MEMORANDUM

To: FILE
From: Nell Donaldson
Subject: Application ID: 2013-179
Date: 8/1/2013

To: Nell Donaldson
Barbara Barhydt
From: David Margolis-Pineo
Re: Review Comments – Bayhouse II – 40 Hancock Street

SHEET 9 OF 14

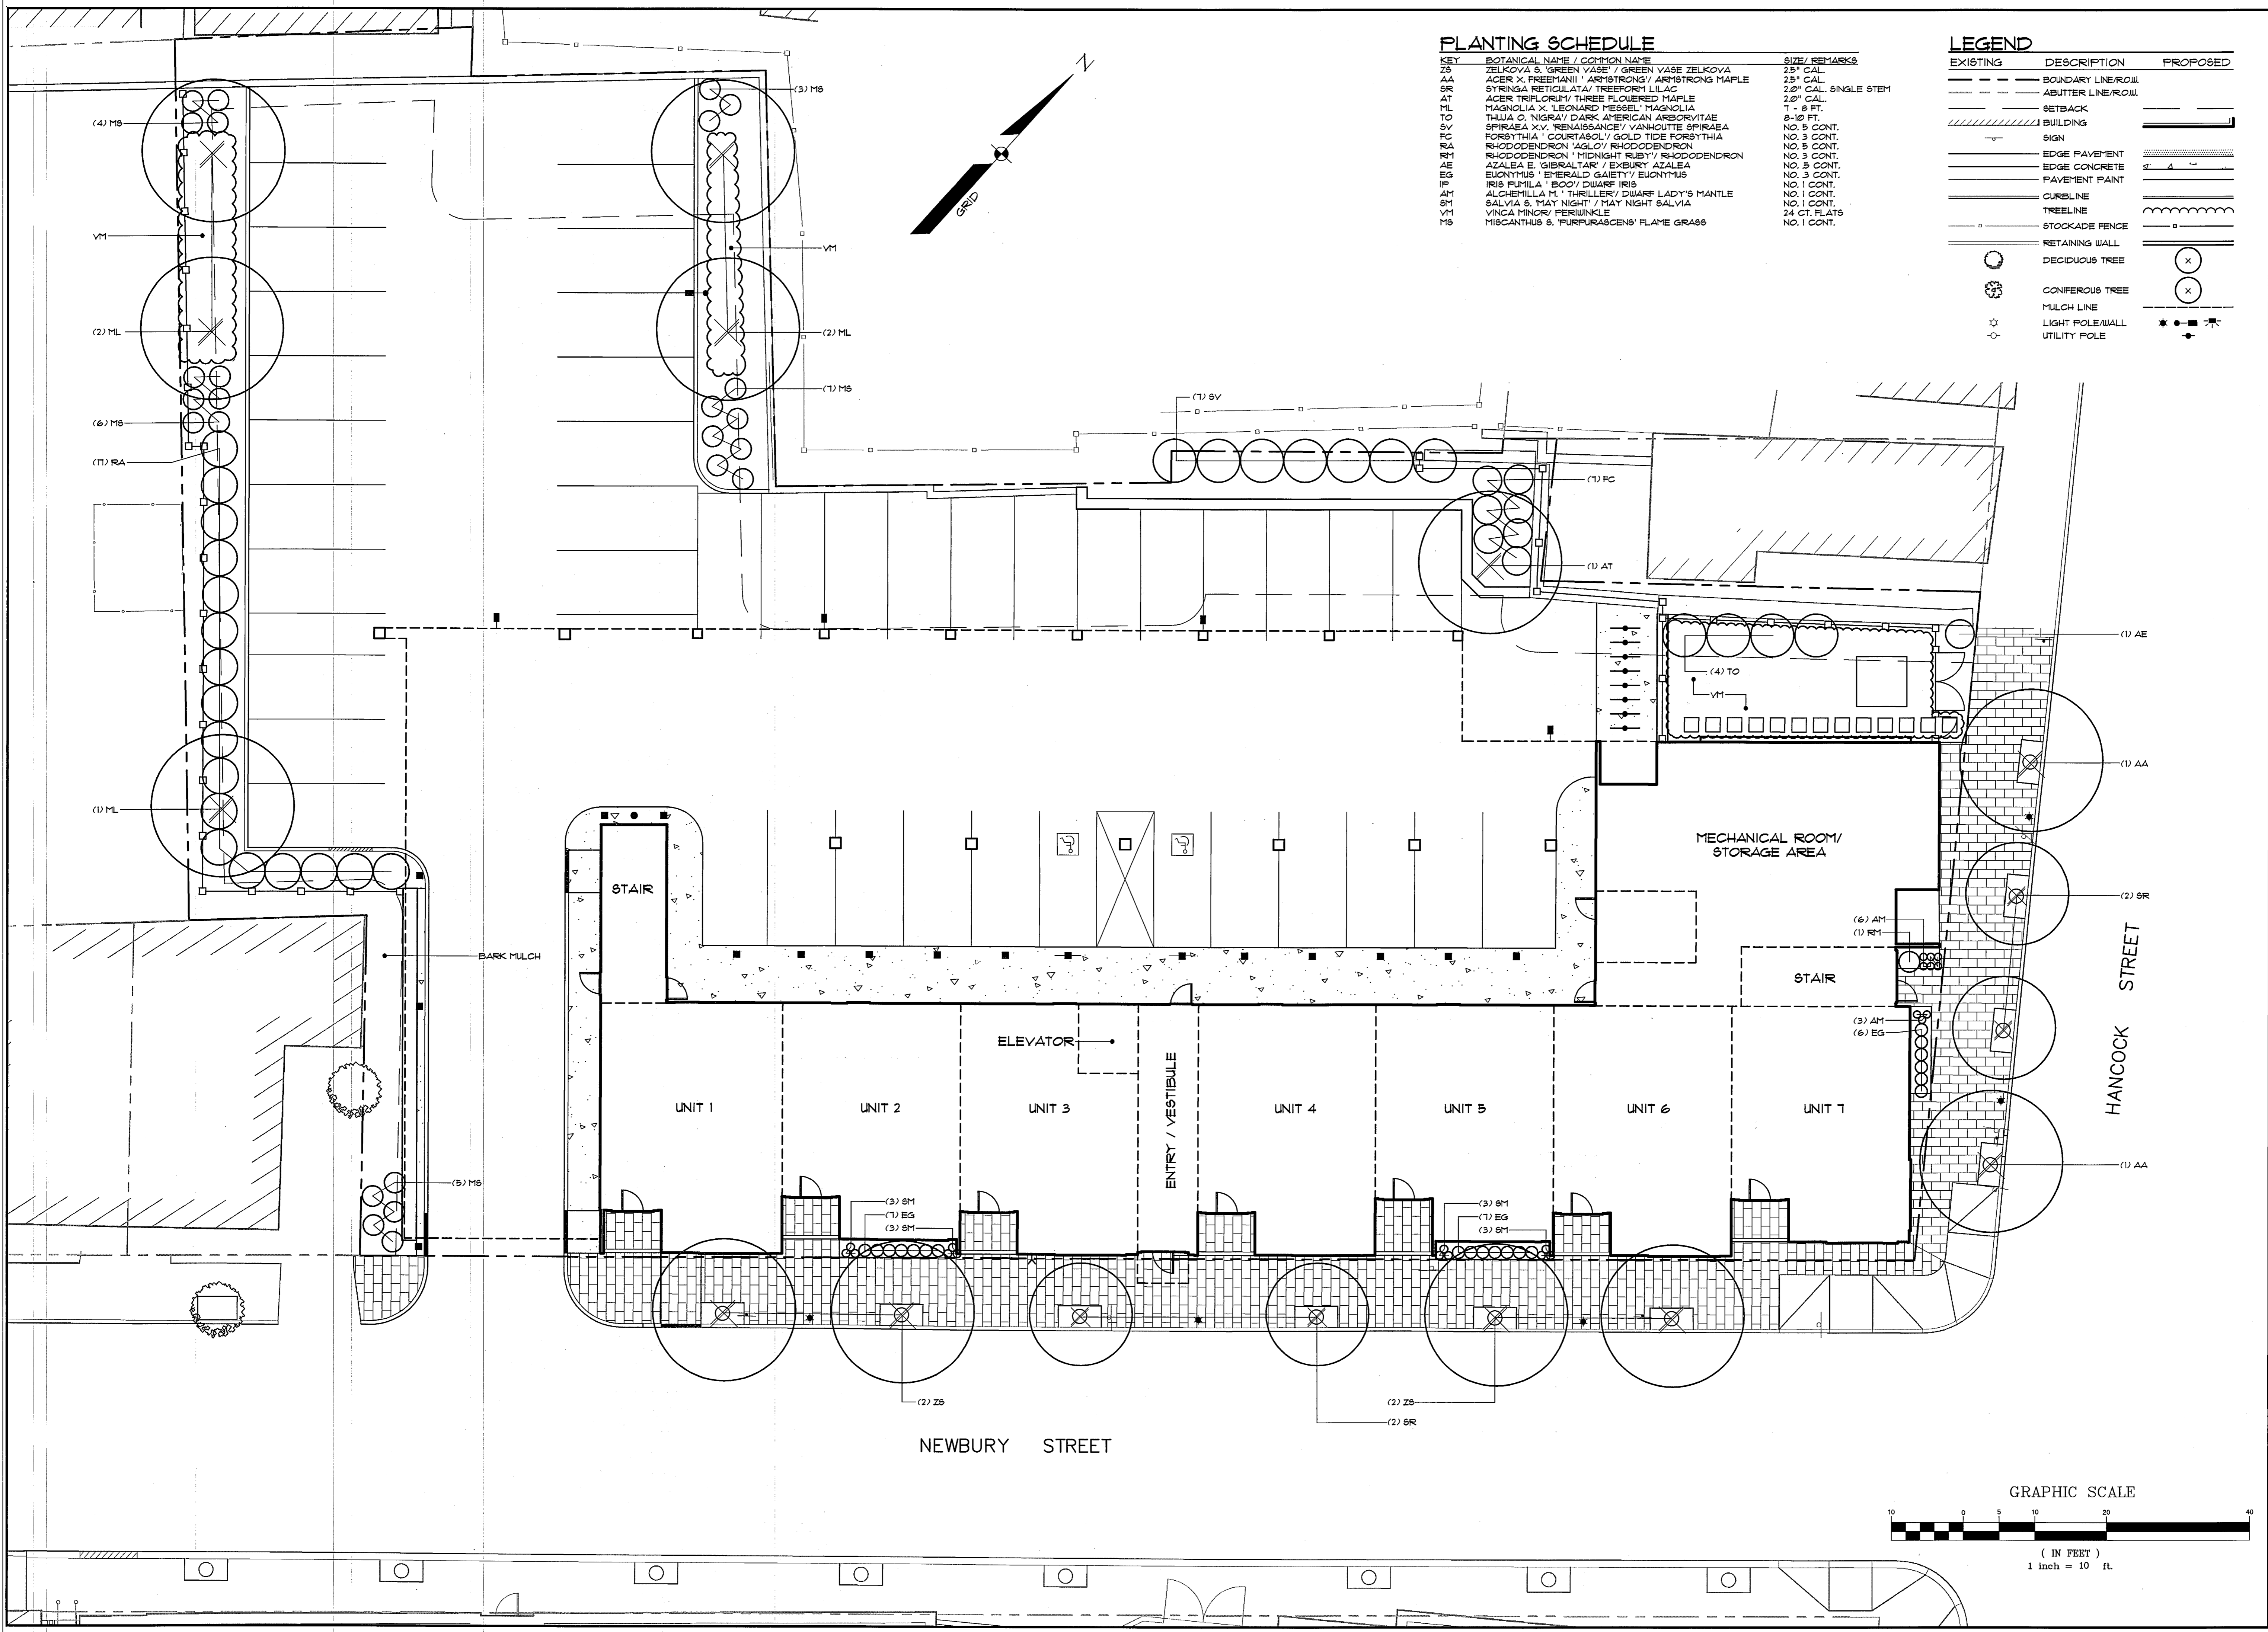
Parking area - review possible alternatives to using groundcover 'Vinca Minor' (VM) while a good groundcover, are their plant options that might provide more interest, screening? (I haven't seen the fence detail or perspective looking at the project from this viewpoint), the plant list could include shrub or herbaceous plants, ornamental grasses...

The proposed Amur Corktree, (PA) should be sized to meet landscape standard of 2" for ornamental trees vs the proposed 6-8' H. Tree options could include Katsura, Three-flower Maple, Tupelo, Korean Mt Ash... Phellodendron's in Portland have all tended to be really slow growing and much less in stature then Southern New England, a 30 year old specimen in Lincoln Park is only about 20' in height with a dbh of 17" !
